# HAYES STRUCTURAL

**Date:** March 7, 2024

**Re:** 23-FRM-021  
Framing Inspection  
Lot 17 Tobacco Road  
187 Golden Leaf Farms Rd.  
Angier, NC 27501  
Permit No.: SFD2401-0065

First Floor Framing Plan
Elevation "C"

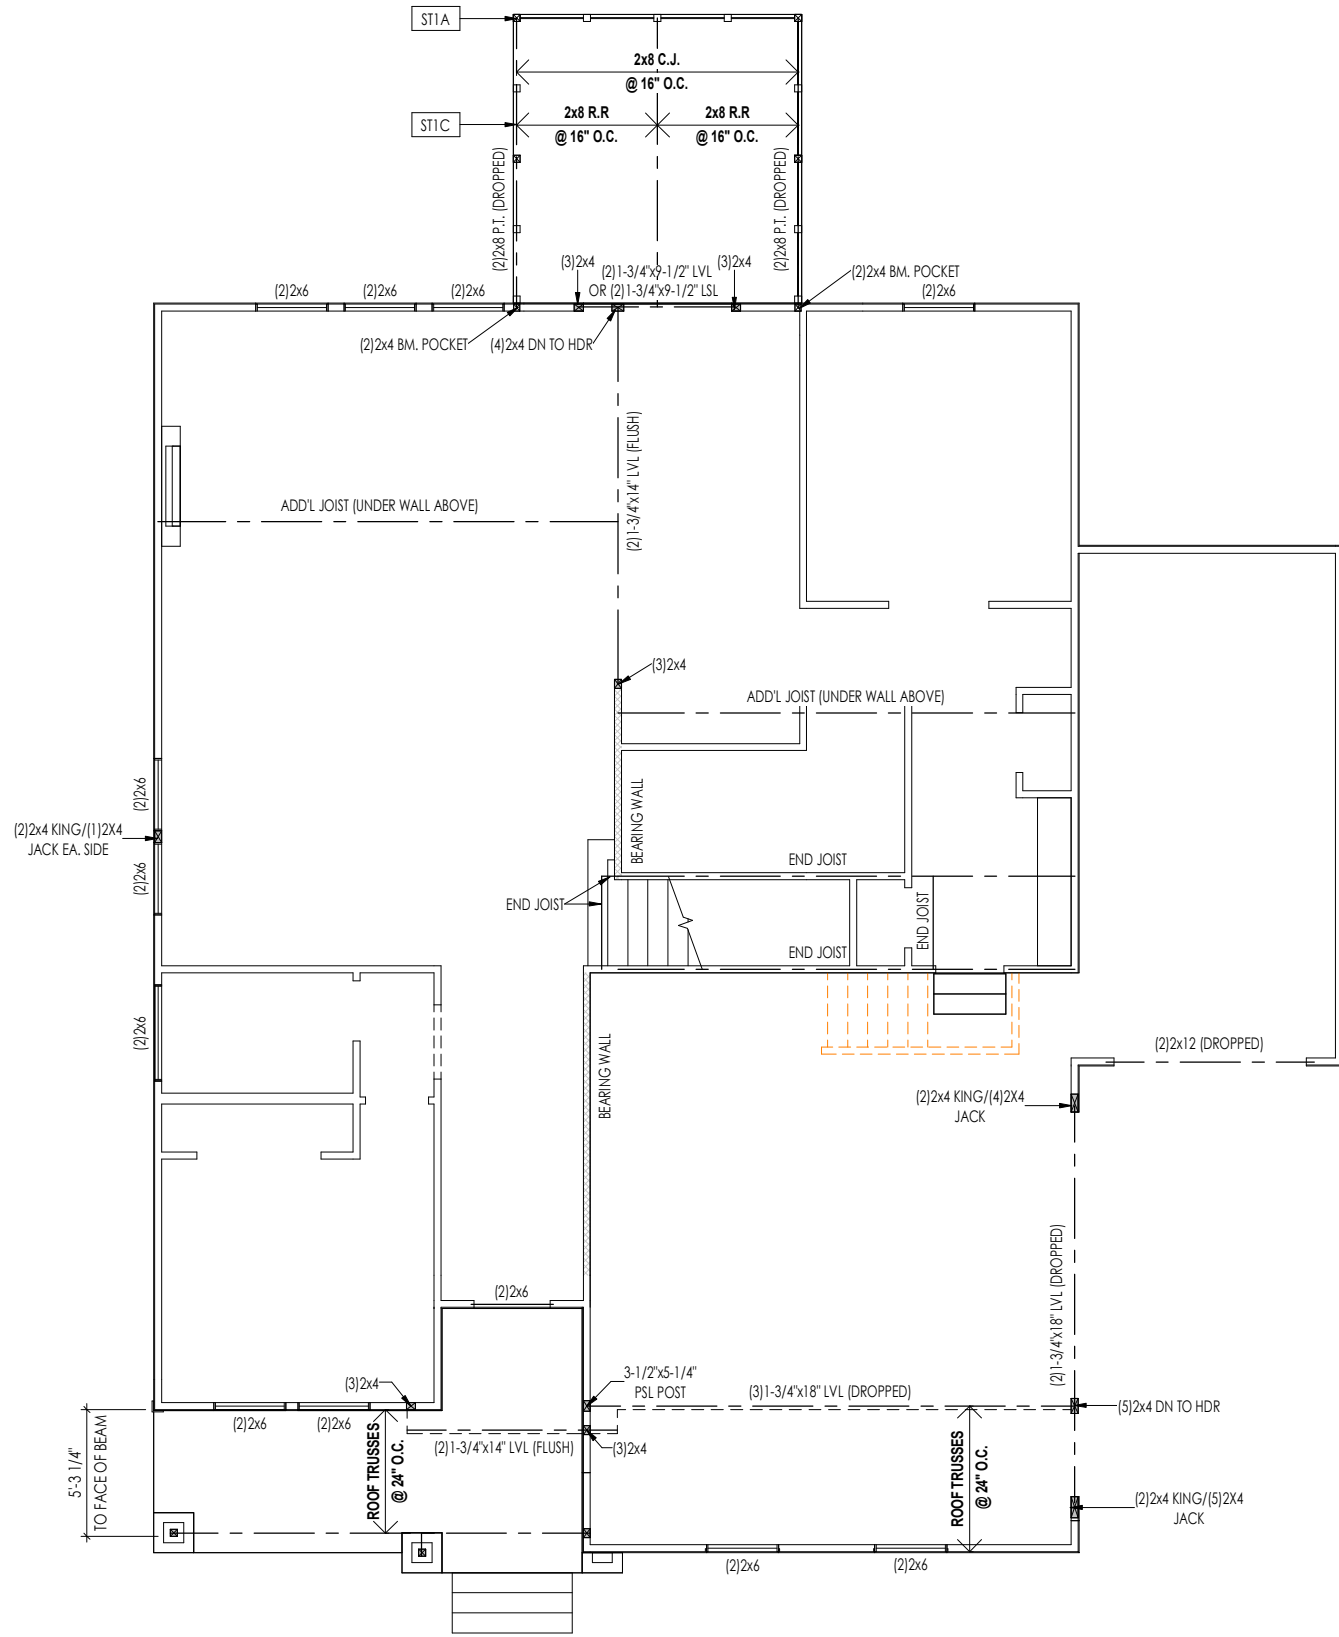
At your request, a site visit was made to the above referenced single family residence under construction to inspect two I-joists within the first floor system beneath bath #2 that were cut to install plumbing.

The eleventh I-joist from the front foundation wall had a +/- 20" section cut out approximately 40" from the left foundation wall to install the toilet drain. The twelfth I-joist from the front foundation wall had a +/- 20" section cut out approximately 6" from the left foundation wall to install the shower drain.

The cut end of the remaining section of the twelfth I-joist at the right side of the shower drain is to be cut back an additional +/- 34" to align with the cut end of the remaining section of the eleventh I-joist at the right side of the toilet drain. A +/- 36" long 14" BCI 5000s-1.8 (or equivalent) I-joist header is to be installed between the tenth and thirteenth I-joists from the front foundation wall to support the cut ends of the remaining sections of the eleventh and twelfth I-joists at the right side of the drains. The remaining sections of the cut I-joists at the left side of the drains are to be removed. New 14" BCI 5000s-1.8 (or equivalent) I-joists spaced 19.2" o.c. are to be installed beneath the toilet and shower spanning between the I-joist header and left foundation wall. New I-joists are to be staggered to avoid interference with the drains while maintaining maximum 19.2" o.c. spacing. The I-joists supporting the header are to be reinforced with an additional full-length 14" BCI 5000s-1.8 (or equivalent) I-joist prior to header installation. Doubled I-joists are to be fastened at the top and bottom flanges with (1) row of 3 1/2" long Simpson Strong-Tie SDS (or equivalent) screws spaced 12" o.c. The header is to be fastened to the supporting joists and the cut and new joists are to be fastened to the header with face-mount I-joist hangers. The webs of the I-joists are to be packed out with OSB per the manufacturer's specifications prior to hanger installation. This prescribed configuration will provide the required support for all imposed loads.
